Department of Transportation

September 28, 2021

RE: Rocky Top Hotel and RV Campground - EA18250

ROCKYTOP MOTEL & CAMPGROUND

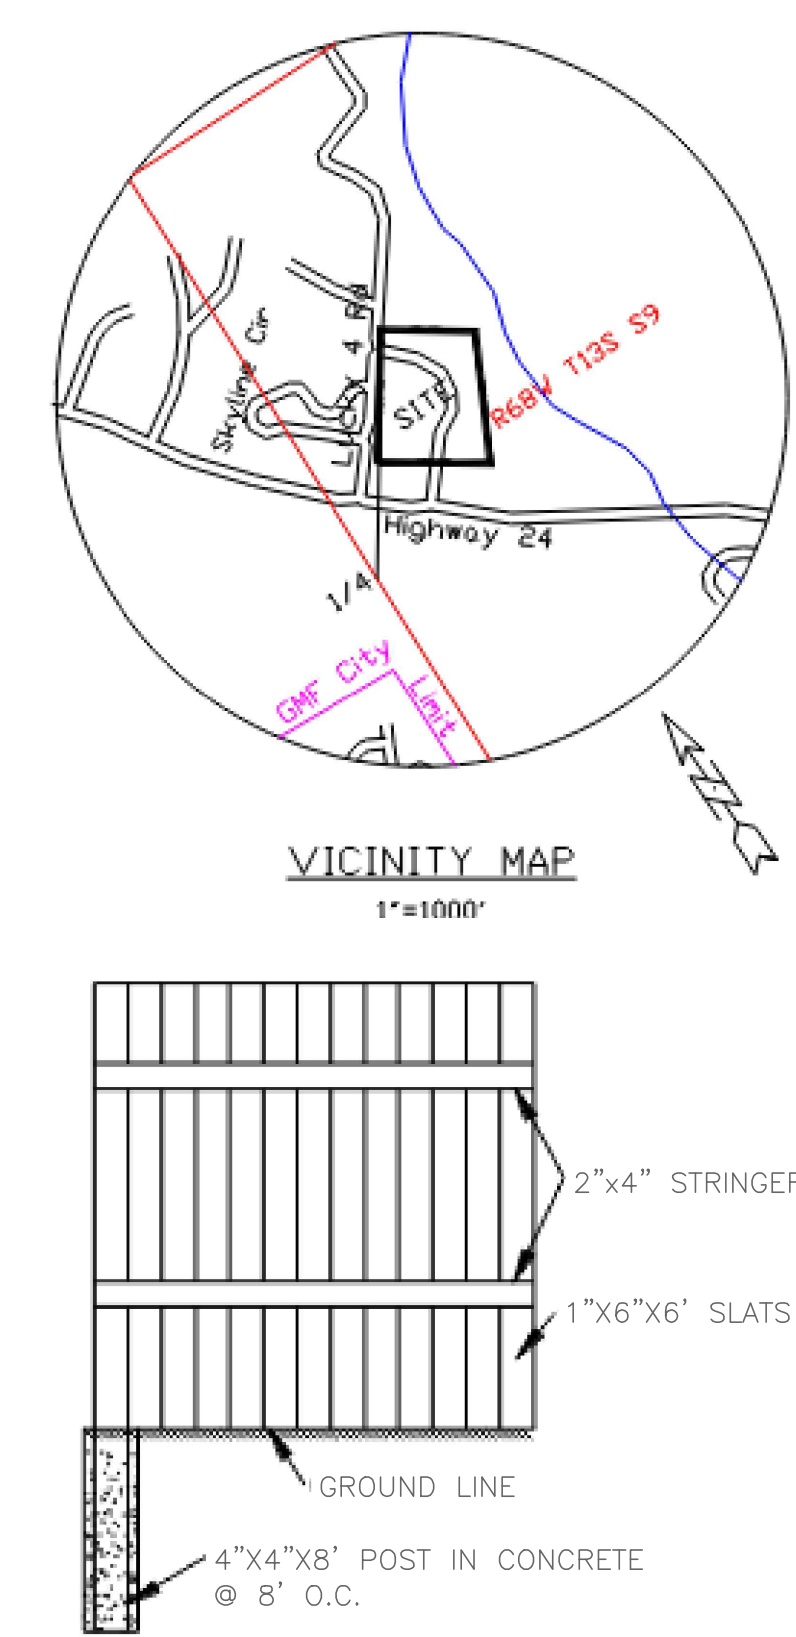
- The access road shown for the historical access (gravel road across CDOT property) along SH24 will need to be relocated to be completely on the Rocky Top Motel and Campground parcel.

- An easement investigation was conducted and we could not find language for an easement within CDOT Rights of Way for the gravel road being used as an access road in CDOT Right of Way.
- We did review the titled "Easement " document provided and found that there are two 30-foot breaks in the Right of Way line for Parcel AC-110 of the CDOT Right of Way Plans.
- With the documents reviewed CDOT staff would like to see the two 30-foot breaks in the Right of Way line drawn on the Plot Plan with dimensions to determine the correct location of breaks.
